EROSION AND STORMWATER QUALITY CONTROL PERMIT (ESQCP) EL PASO COUNTY APPLICATION AND PERMIT

Project Information	
Project Name	Falcon Family Eye Care
Legal Description	Lot 1 Woodmen Hills Filing No. 7H
Address (or nearest major cross streets)	7615 McLaughlin Road
Acreage (total and disturbed)	Total: 1.11 acres Disturbed: 1.0 acres
Schedule	Start of Construction: February 2021 Completion of Construction: December 2021 Final Stabilization: February 2022
Project Purpose	Construct a commercial building.
Description of Project	Replat Lot 4 Woodmen Hills Filing No. 7 into 2 lots. Lot 1 is being developed with this application.
Tax Schedule Number	4306301002

DRAINAGE MAPS

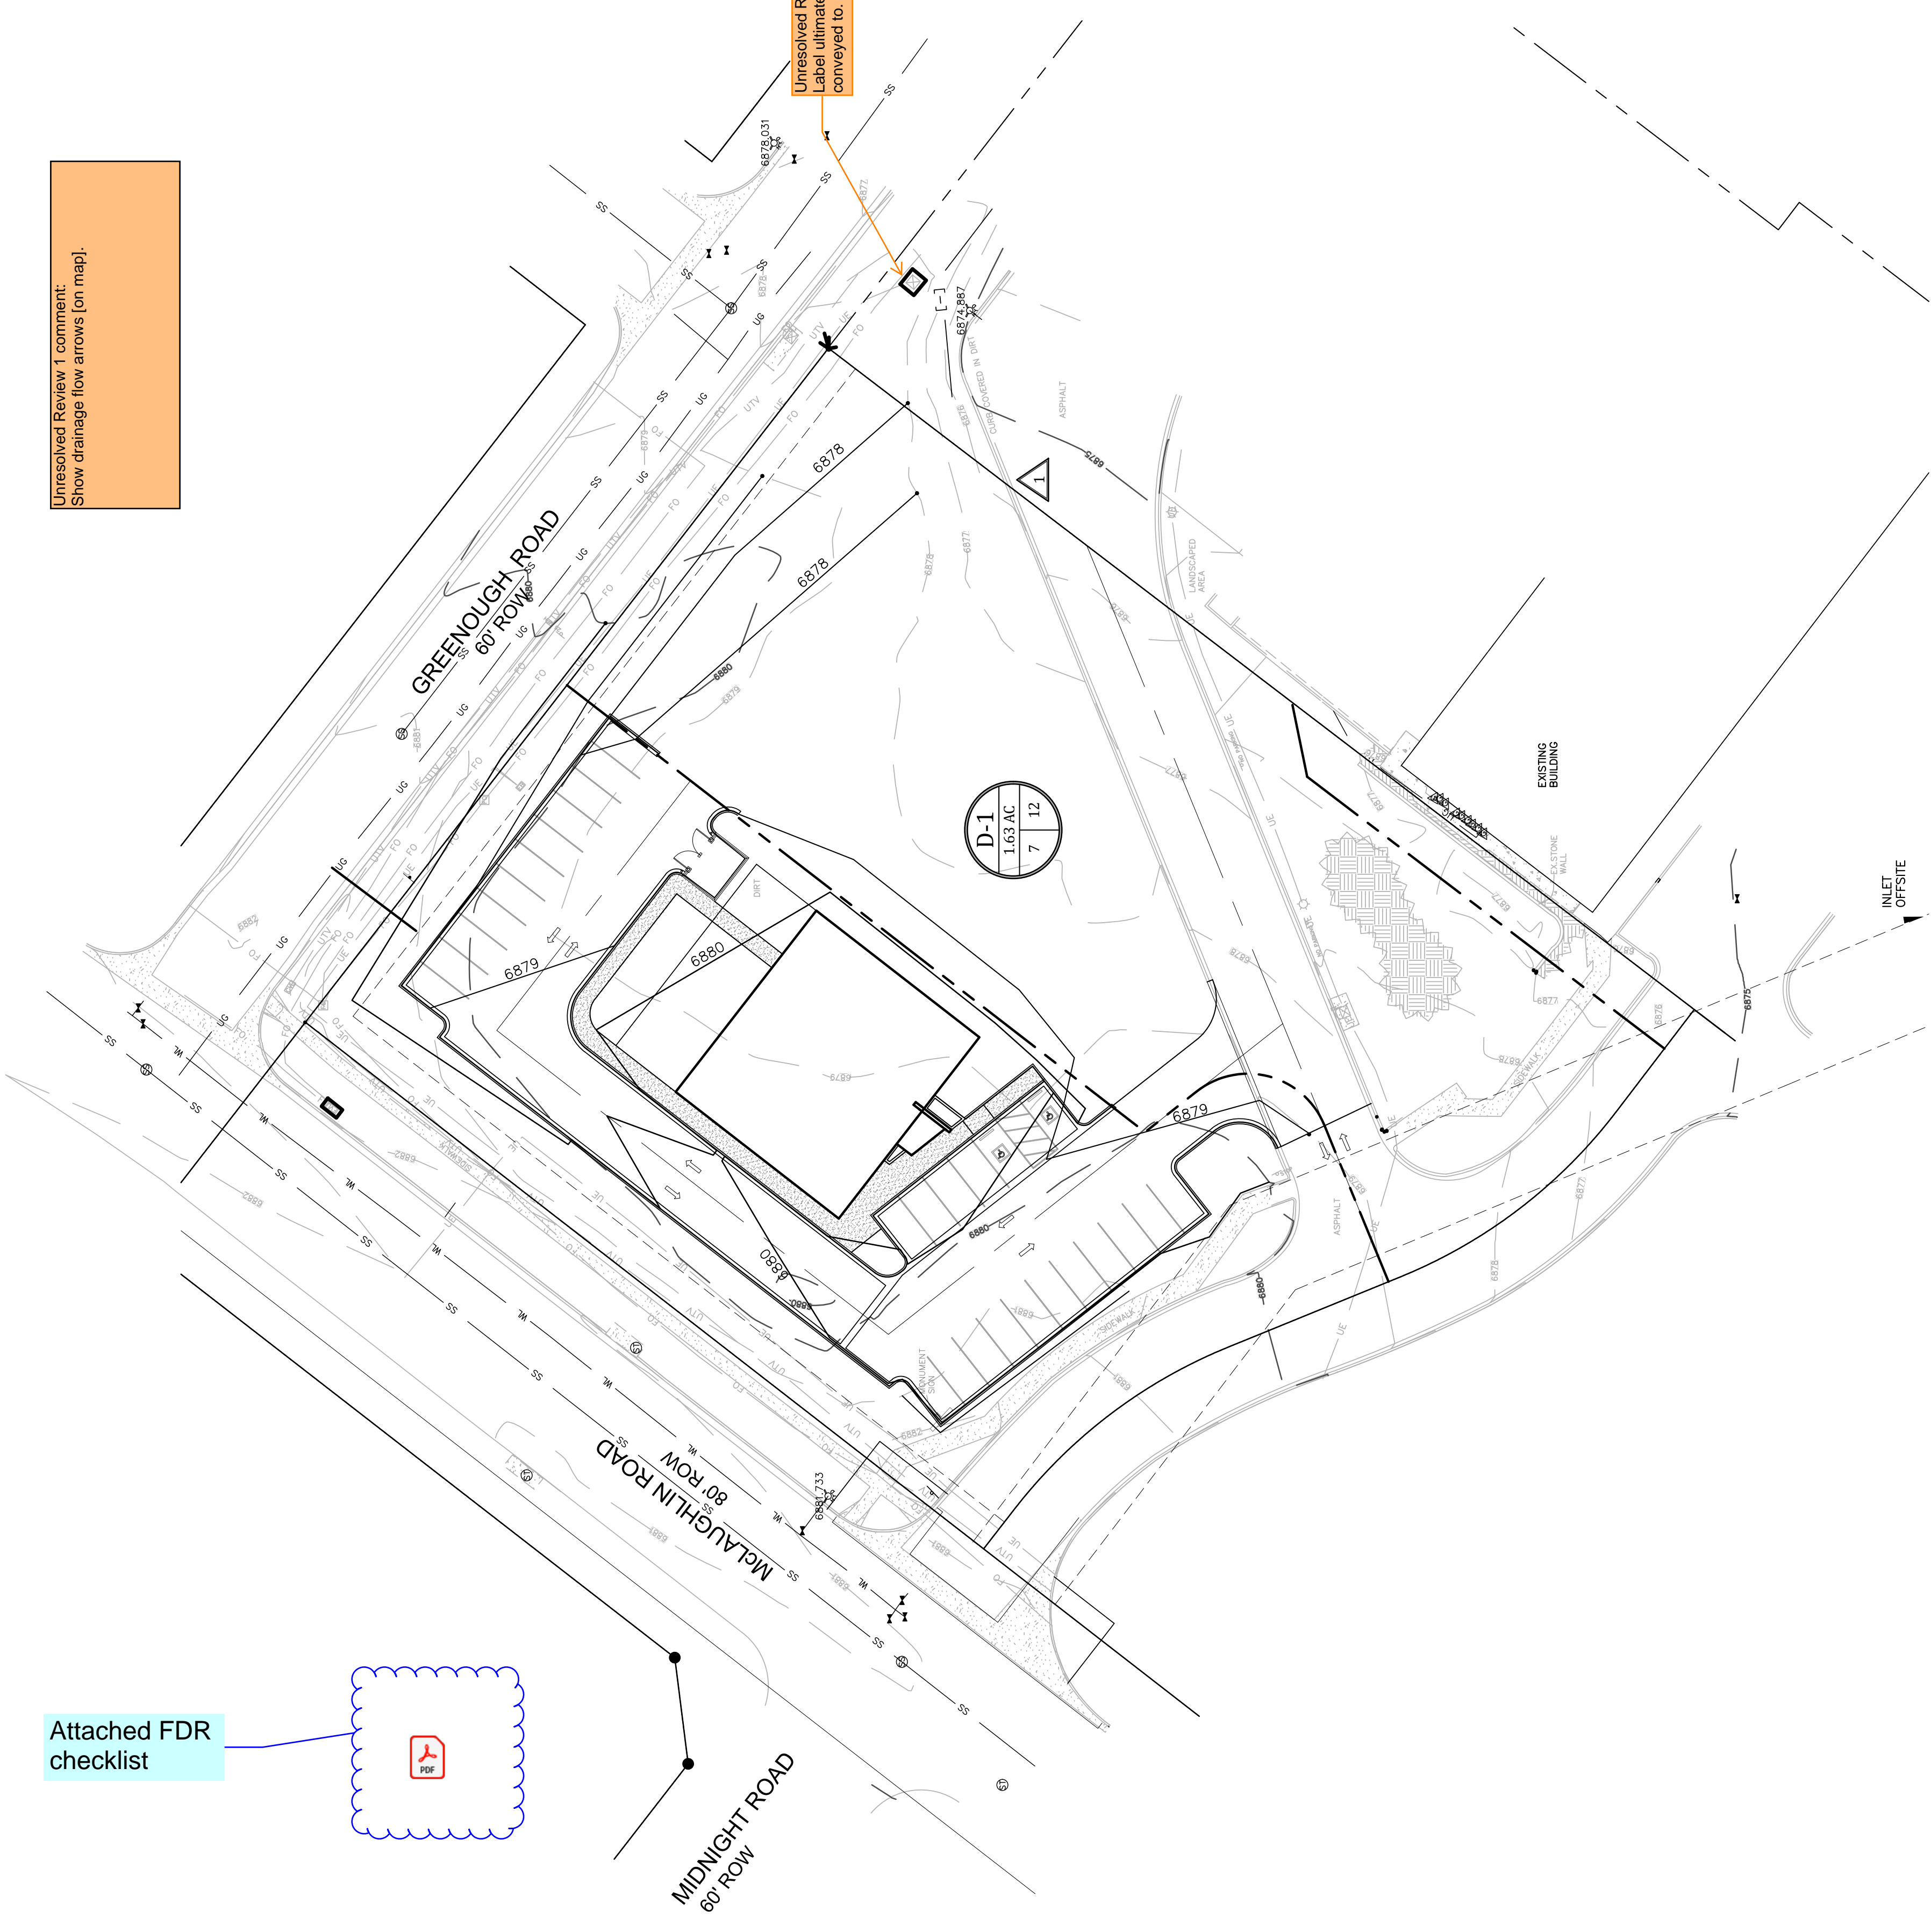
← Does not match the 0.79 acres listed in the Drainage Letter and Application. Revise.
